# CITY OF ALBUQUERQUE

April 27, 2015

**RE: DaVita Dialysis Center, 5207 San Mateo Blvd.  
Grading and Drainage Plan  
Plan Dated 4-20-15 (File: F17-D095A)**

Drawing file: F17D095A / C5.0 DRAINAGE AREA MAP.pdf

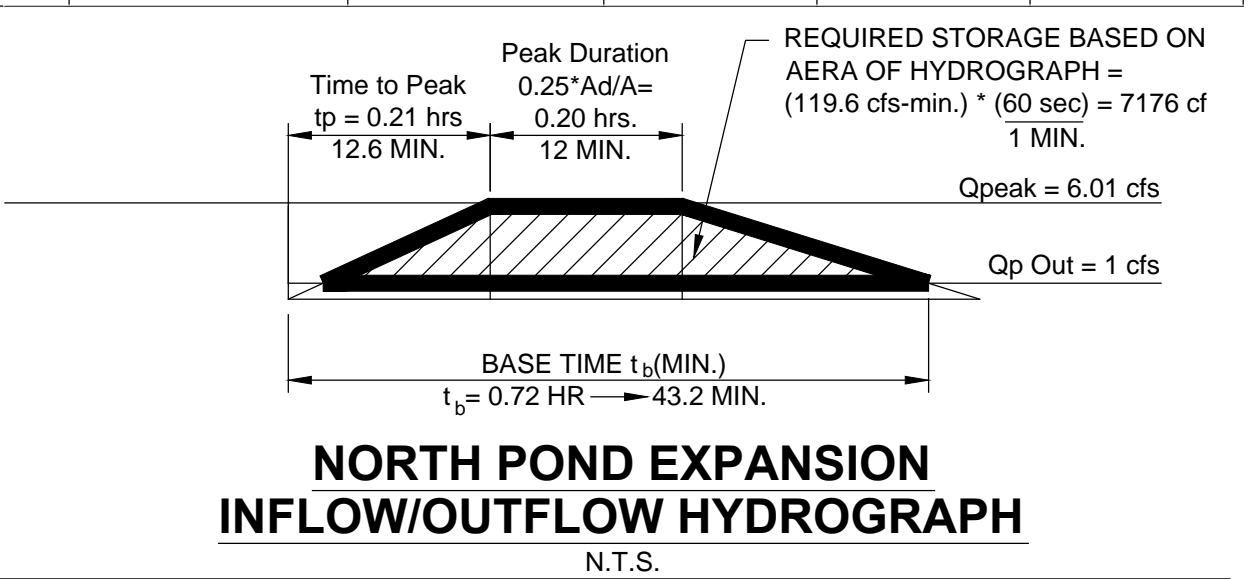
Prior to receiving approval on this project for Building Permit, please include all of the drainage calculations that you provided on 4/27/15 within the final drainage report. On the Sheet C5.0, include your computed WSEL for the 100-year-storm, the total volume provided for the storage pond, and the corresponding pond volume at the WSEL. Also, on Sheet C5.0, show all basins that contribute to the north pond which shall include all off-site stormwater runoff from the Golden Corral parking lot.
